## **AQUIND INTERCONNECTOR**

Consultation Report – Appendix 1.7F Marine  
Specific – Briefing Note for Ongoing  
Consultation with JNCC August 2019

Natural Power Memorandum			
To	JNCC	Date	August 2019
From	Natural Power	Ref.	1199521

## Brefing Note for Ongoing Consultation: Responses to PEIR Feedback

Figure 3.7 - Atlantic Cable Crossing

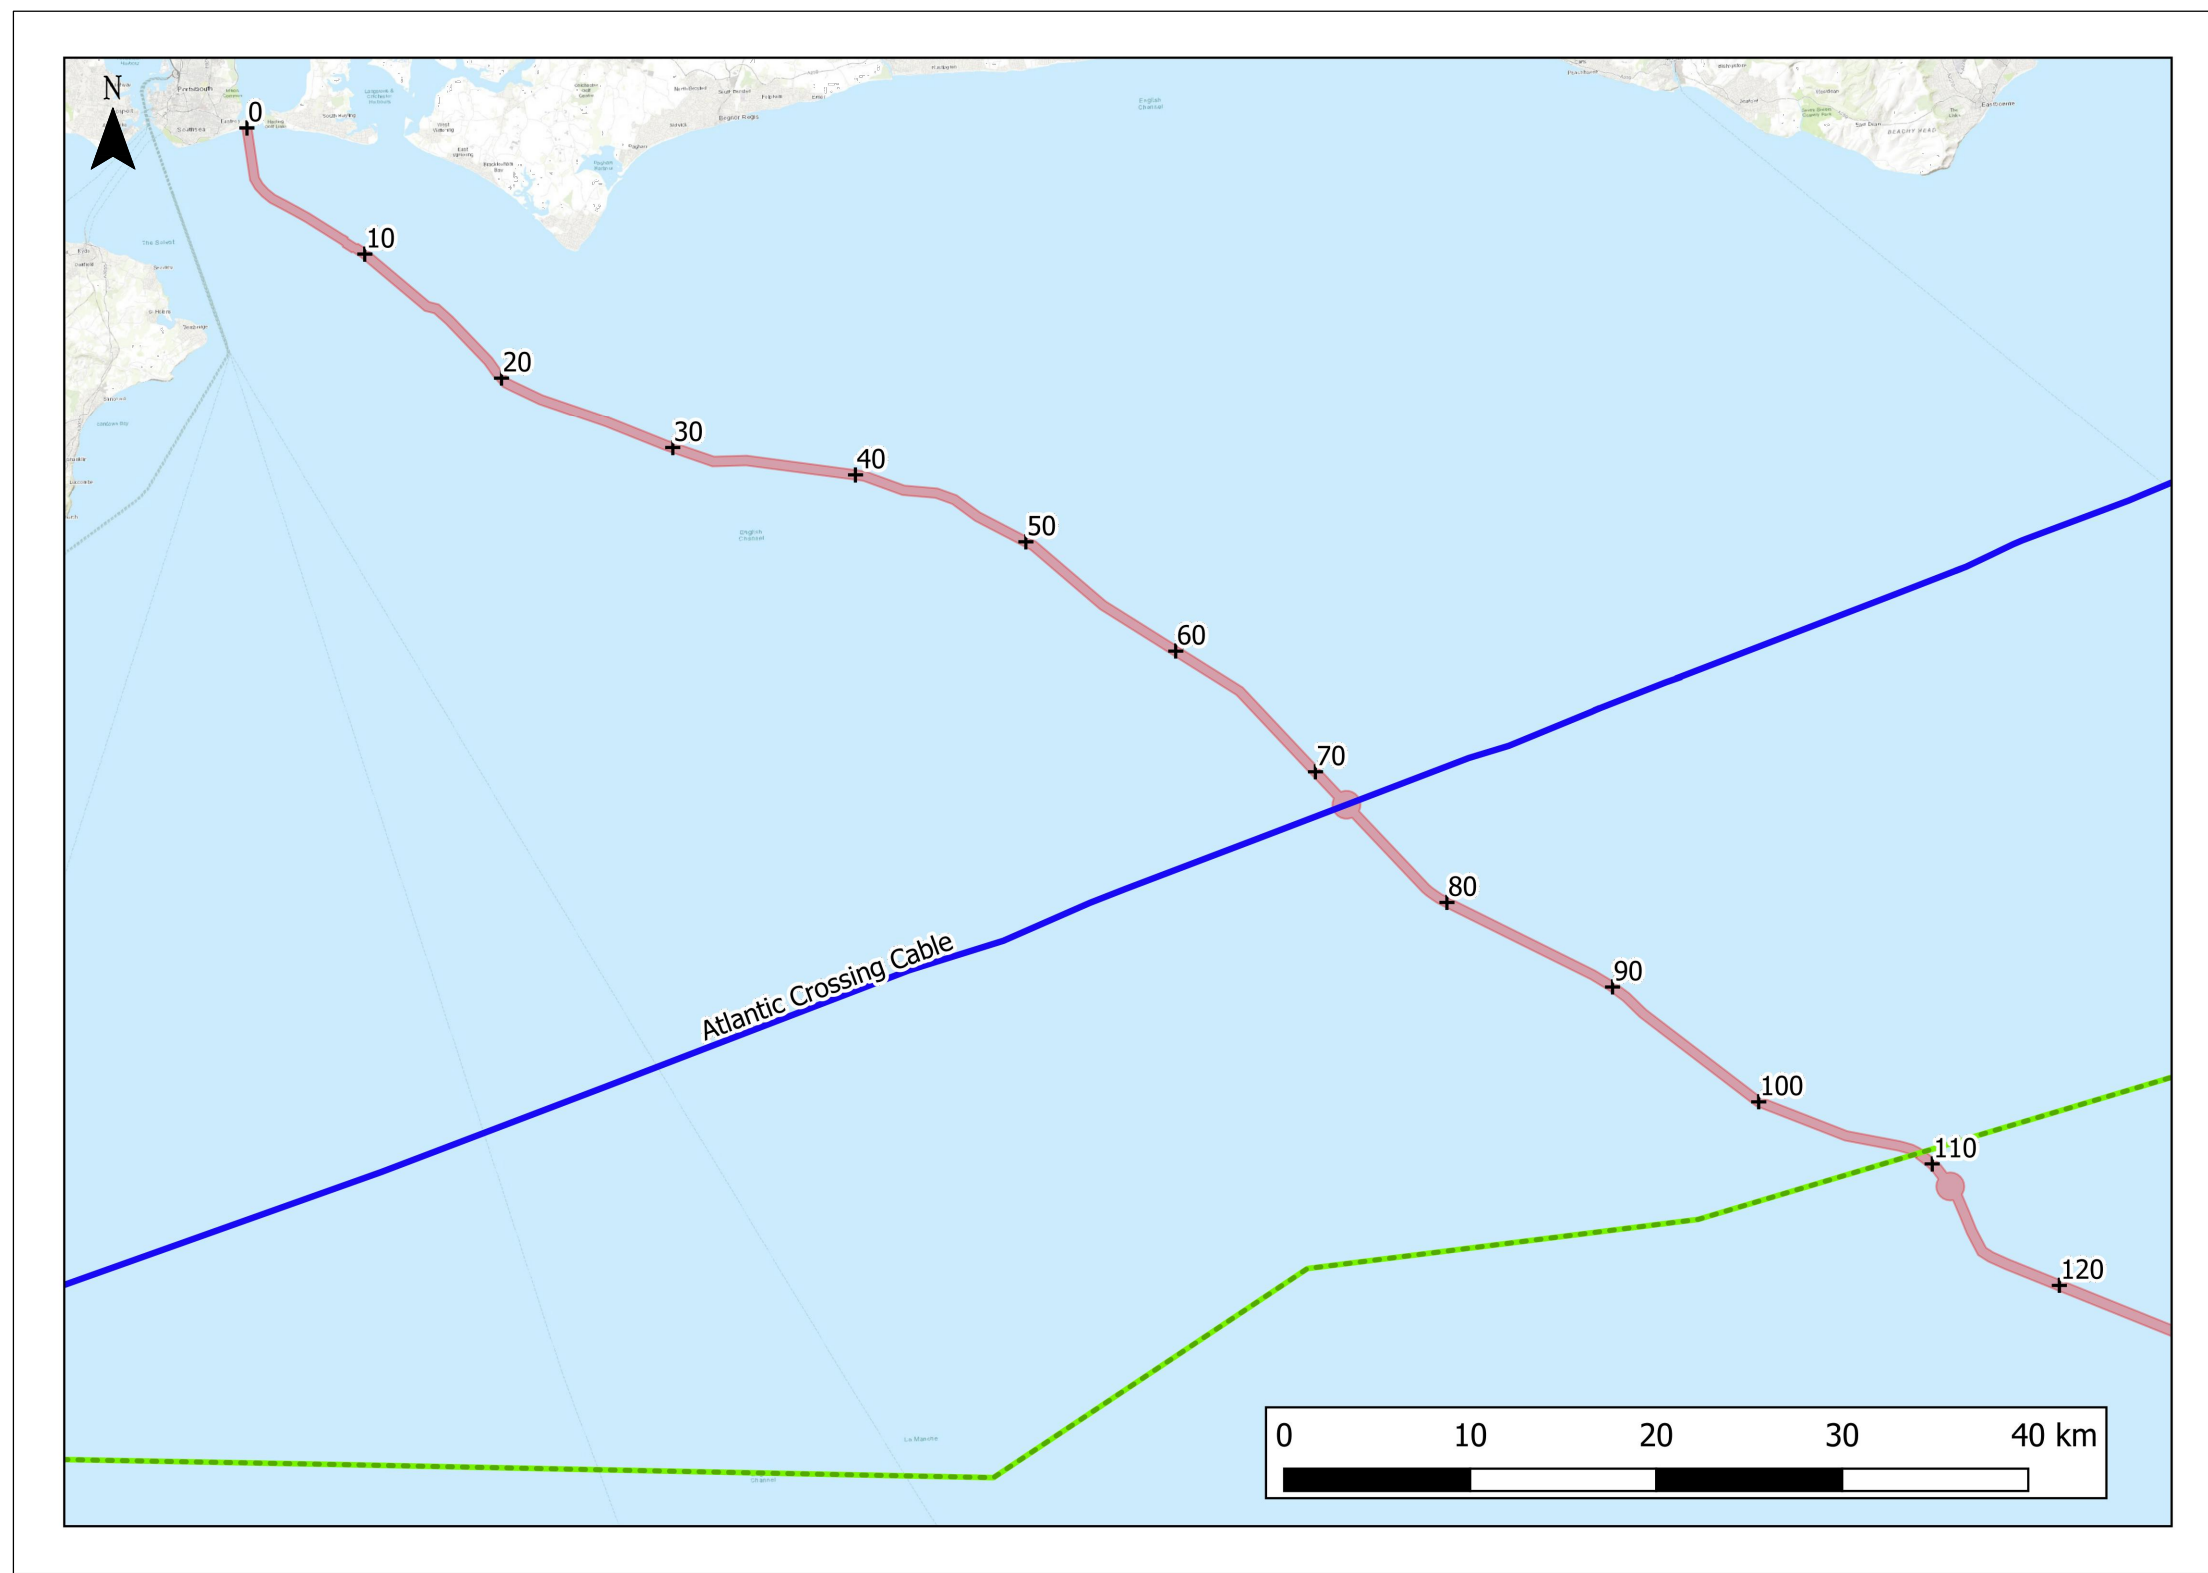
10	<b>Intertidal and Benthic Ecology</b>	The operation potentially involves the introduction of hard substrate into a mainly sedimentary environment. Although the changes are not necessarily considered as having a significant impact in this instance, we still encourage the operator to continue working to minimise the amount of hard substrate material used. We note that the long-term effects of the introduction of substratum into naturally sandy or muddy sea beds is not fully understood at present and should be carefully considered by the regulators.	Acknowledged. It is the preference of the Applicant to bury cables, where it is possible, to sufficient depths in order to protect the cable; this will be the case along the majority of the cable route identified to date. Non-burial protection will be proposed in areas where the target burial depth is not achievable or at areas where alternatives do not exist such as the Atlantic Cable Crossing and the HDD exit/entry location. The potential impacts of

Item	Topic	Comment	Applicant's Response
			placement of non-burial protection will be assessed within the relevant chapters of the final ES.
11	<b>Intertidal and Benthic Ecology</b>	<p>JNCC welcome detailed commentary on stabilisation operations to allow further understanding of their actual nature conservation impact. This would include:</p> <ul style="list-style-type: none"> <li>• Location of dump sites;</li> <li>• Size / grade of rock to be used;</li> <li>• Tonnage / volume to be used;</li> <li>• Contingency tonnage / volume to be used;</li> <li>• Method of delivery to the seabed;</li> <li>• Footprint of rock;</li> <li>• Assessment of the impact;</li> <li>• Expected fate of deposit after end of production, i.e. will it be left in situ or recovered.</li> </ul> <p>Where stabilisation material cannot be avoided, we recommend using a more targeted placement method e.g. fallpipe vessel rather than using vessel-side discharge methods.</p>	<p>The ES will present as much detail as is possible based on the information known at the time. It is important to bear in mind that this level of detail and location of non-burial protection will need to be confirmed prior construction due to the changing nature of the seabed and will be informed by pre-construction surveys. The ES can present typical values for size/grade of rock and tonnage/volume of rock to be used in specific areas such as the cable crossing and the HDD exit/entry location however, this information would be need to be reviewed after the results of pre-installation surveys are known and reported on through the Cable Burial and Installation Plan (and/or Cable Protection Plan).</p>
